CITY OF ALBUQUERQUE

Re: Retail Spaces
8737 Central Ave. NW
Traffic Circulation Layout
Architect's Stamp 06-22-23, Revised 9-29-23 (K09\D053)

Based upon the information provided in your submittal received 12-22-23, the above referenced plan cannot be approved for Building Permit until the following comments are addressed:

Curtis Cherne, PE
Senior Engineer, Planning Dept.
Development Review Services

TCL

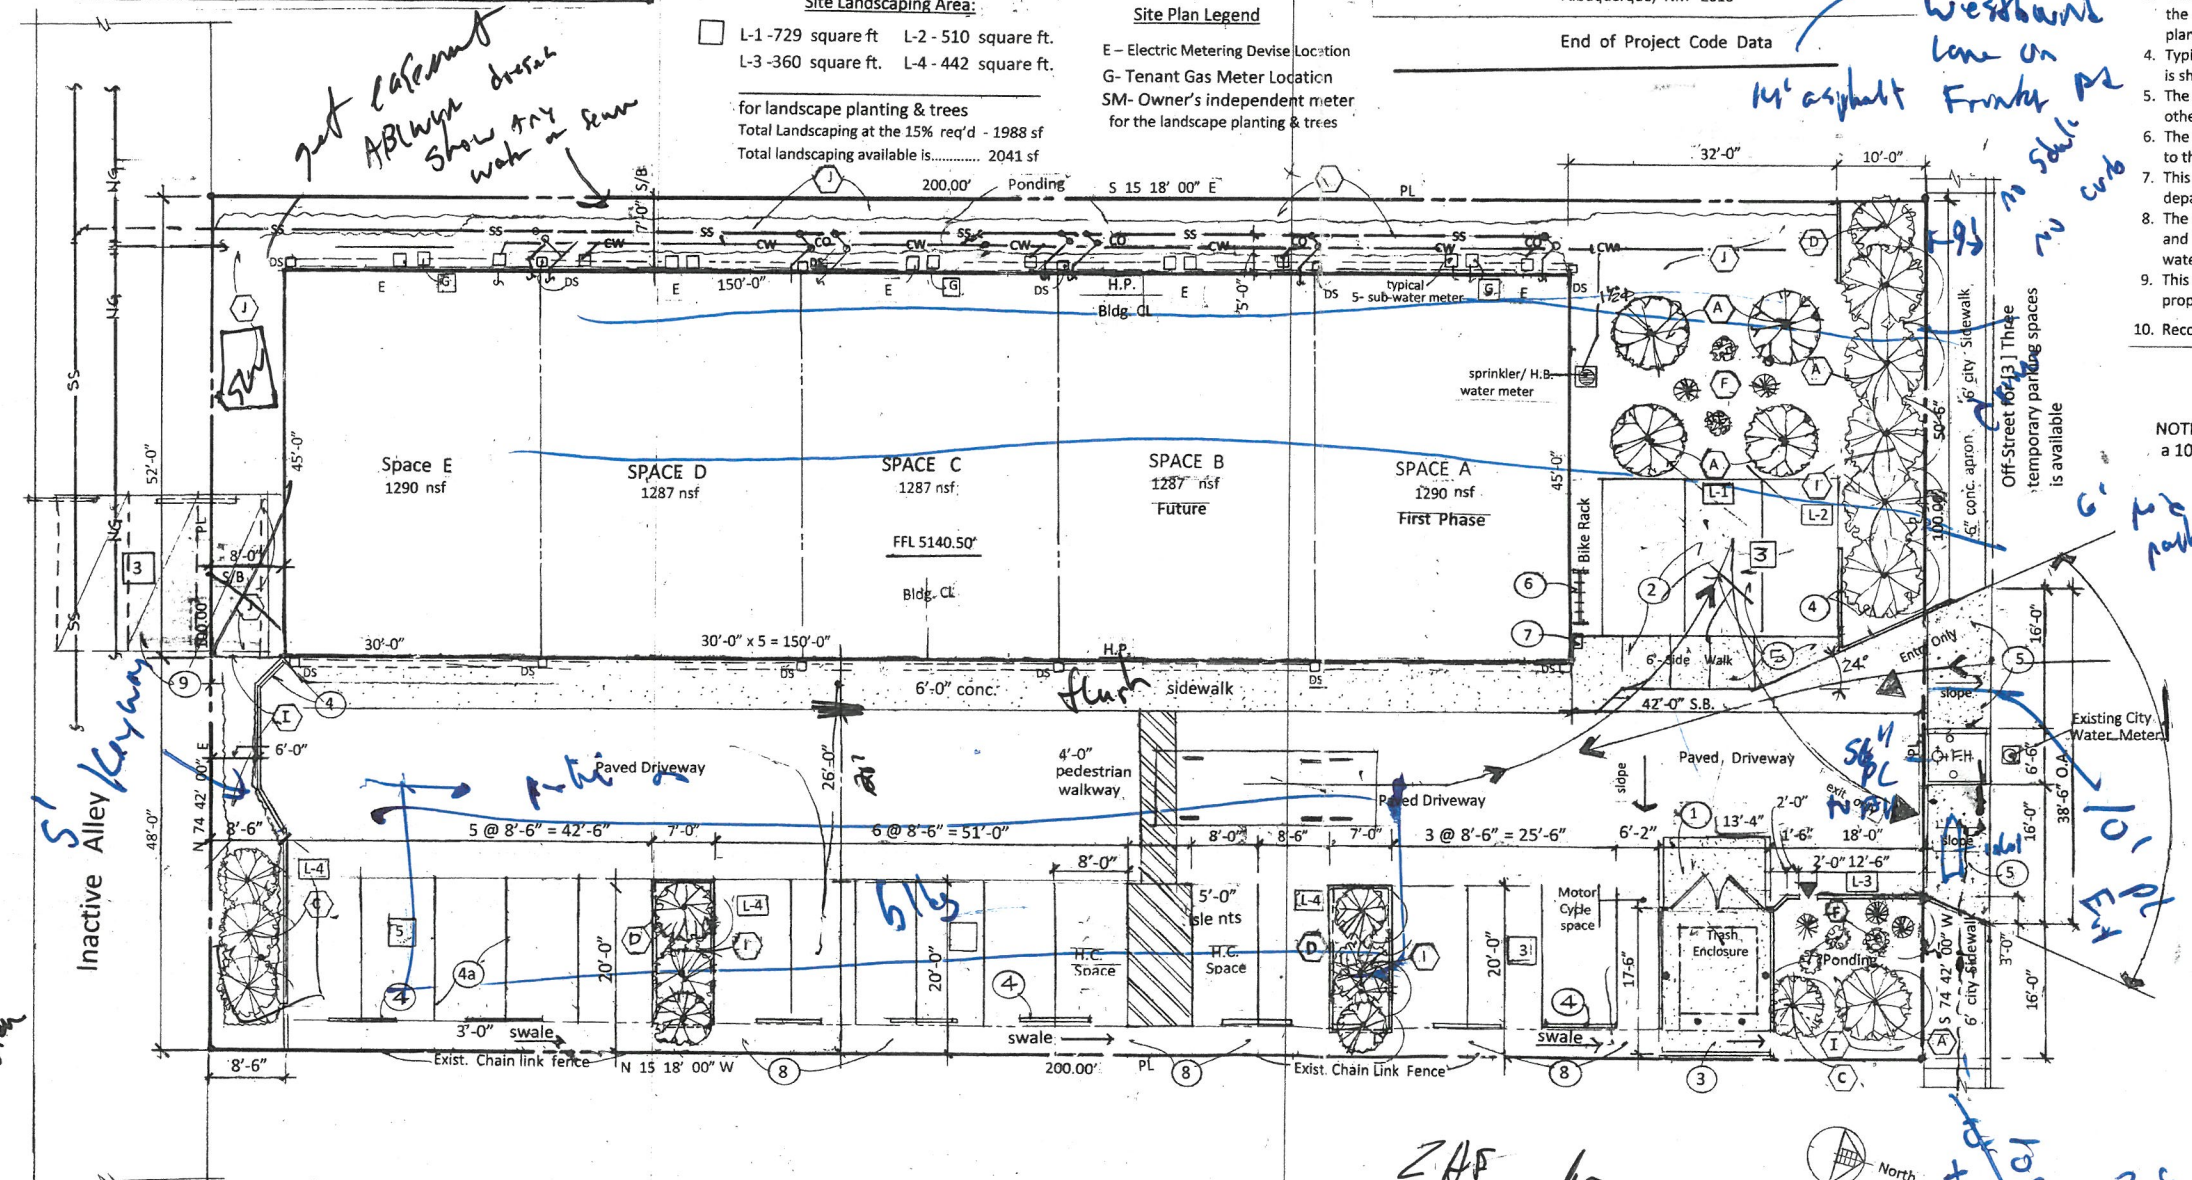
4. The entrance should not have a Fire Hydrant in the middle of it. It is not clear at this time, which will be moved, the fire hydrant or the entrance.

6. It appears the drive aisle is only 20 feet wide. The minimum for two-way traffic is 22 feet.
7. A vicinity map will be added to the plan.

11. Parking stall sizes are shown on the plan, however, per the City's DPM, accessible spaces are to be 8.5' wide and the bike rack should be detailed. The City has a rather long list of requirements for the bike rack, but a bike rack of the inverted "U" design meets the DPM and can park 2 bicycles each. They are also to be on a concrete pad. A detail will help the Contractor be successful. Incorrect installations are observed too often.

12. Van accessible aisles appears to be 5' wide on the plan. It is drawn to 8', but note calls out 5'.
13. The ADA signage, pavement markings, motorcycle signage and bicycle parking are to be designed by the Architect or Engineer and not left up to the Contractor to decide.

17. A 5' keyway is required at the north end of the parking lot.
18. The ADA accessible pedestrian pathway from the sidewalk/street to the site can be developed after the DHO hearing as mentioned above.

23. The delivery truck must have a dedicated back-up location. This could be coordinated with the Solid Waste truck movement.
24. Keyed Note 4. Something permanent like curb should be built.

25. Revise Keyed Note 6 as discussed previously.
26. Revise Keyed Note 2 as the large truck should be backing-up across a sidewalk.
27. For Keyed note 8. I recommend not using asphalt for the swale as concentrated flows will degrade the asphalt in approximately 5 years. In addition, the approved grading and drainage plan shows a curb along the west edge of the swale with openings for drainage. Hence, the swale is dirt/landscaping.

28. Remove Keyed Note 9. This is not a good place for a parking space as it is hard to drive into due to the corner of the building and there is no keyway for this vehicle to back into.

29. Keyed Note 10. The dimension/size of a parking stall is dictated by the striping. So if the striping is 18' long so is the parking space. 18 feet long is the minimum length. Specifying an 18' long parking space may also help you obtain the required 22' minimum drive aisle width.

30. Remove the improvement shown in the alley. The alley is City property and they are used for access, not for storage.
31. To summarize: it appears you should wait to resubmit the plan after the platting action, vacation action parking reduction hearing and sidewalk waiver items are resolved.
